Item No. **Report of the Head of Development Management and Building Control**

Address: 37 FAIRHOLME CRESCENT HAYES

Development: Retention of single storey rear extension (Retrospective application).

LBH Ref Nos: 20685/APP/2023/2201

Applicant: MR SATNAM MASIH			
Job Title: 37 FAIRHOLME CRESCENT, HAYES, UB4 8QT			
Drawing Title: PROPOSED GROUND FLOOR PLAN			
Scale: 1:50 Date: 24/06/2023	Drawing No. PA-2341-04	Print Size A3	Revision
Drawing Status FOR PLANNING APPROVAL

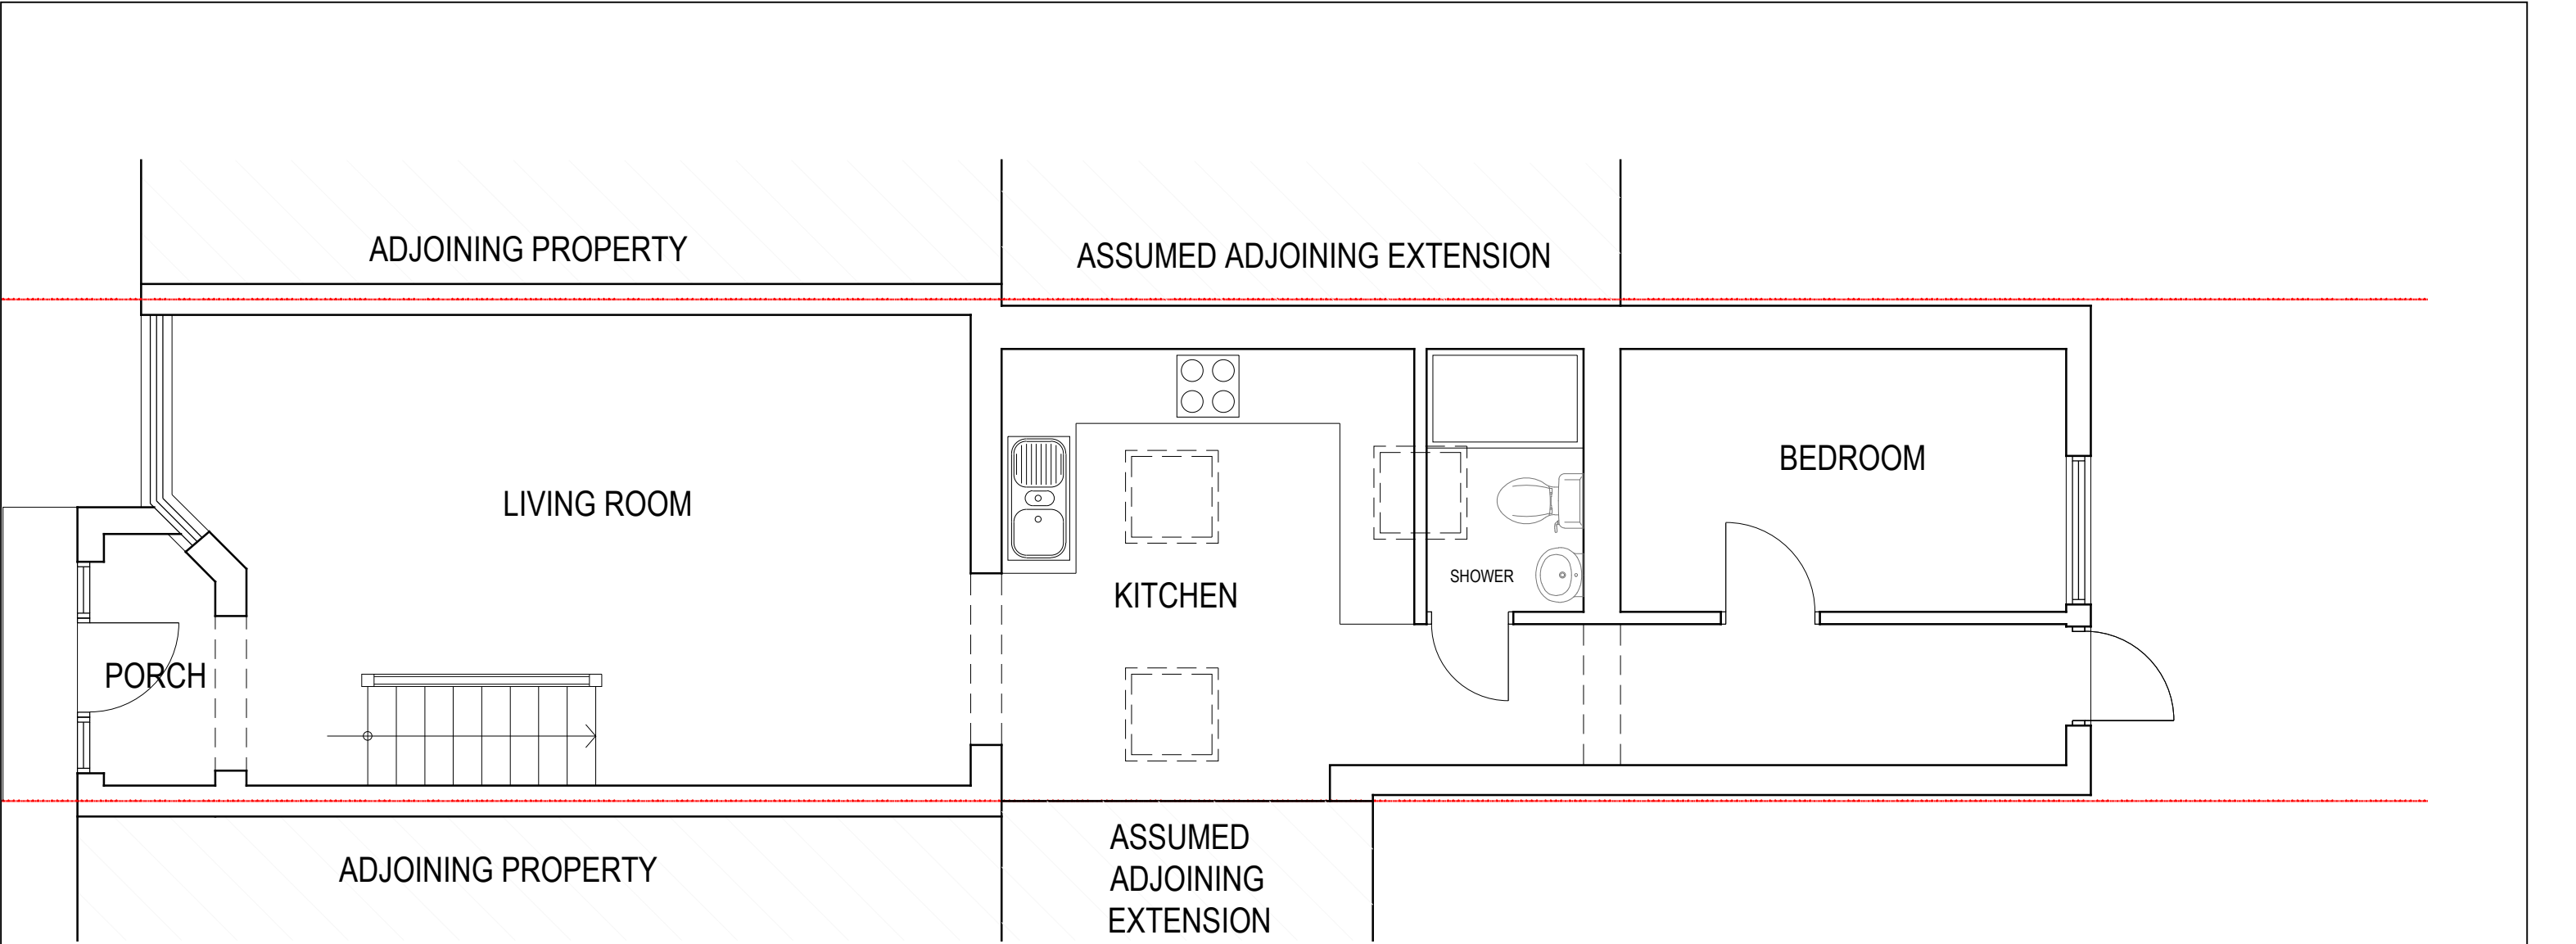
The retrospective development consists of a single storey rear extension which has been attached to an existing extension at the property. The cumulative extension measures 8.8m deep and varies from 2.6 to 2.9m in height. It is noted that the previous single storey rear extension does not appear to have planning permission.

The retrospective extension which planning permission is sought for would result in a cumulative extension which is significantly over the depth allowed under Policy DMHD 1. Due to its excessive depth and bulk the extension has caused harm to the original dwelling house by substantially increasing its original footprint and forming a visually disproportionate addition.

Overall it is considered that due to the substantial depth, the existing extension would cause harm to the character and appearance of the existing dwelling and area. It therefore fails to comply with Policies DMHD 1, DMHB 11 and DMHB 12 of the Hillingdon Local Plan: Part Two - Development Management Policies (2020).

No.39 Fairholme Crescent is located north of the application site and forms part of the row of terraced properties. The property does benefit from a small single storey rear extension. The retrospective extension constructed at the development site projects approx 5.80m deeper than the rear building line of this neighbour. Due to its combined height and depth the extension has caused overshadowing and a significant loss of light to the habitable rooms within this neighbouring property. Due to the depth of the extension, it would appear as over dominant and overbearing to this neighbour. It has also caused a unacceptable enclosing impact.

As such, the proposal, would cause unacceptable loss of light, overshadowing and be overbearing to the adjoining neighbour no.39 Fairholme Crescent. Therefore the proposal would not comply with Policies DMHD 1 and DMHB 11 of the Hillingdon Local Plan: Part Two - Development Management Policies (2020).
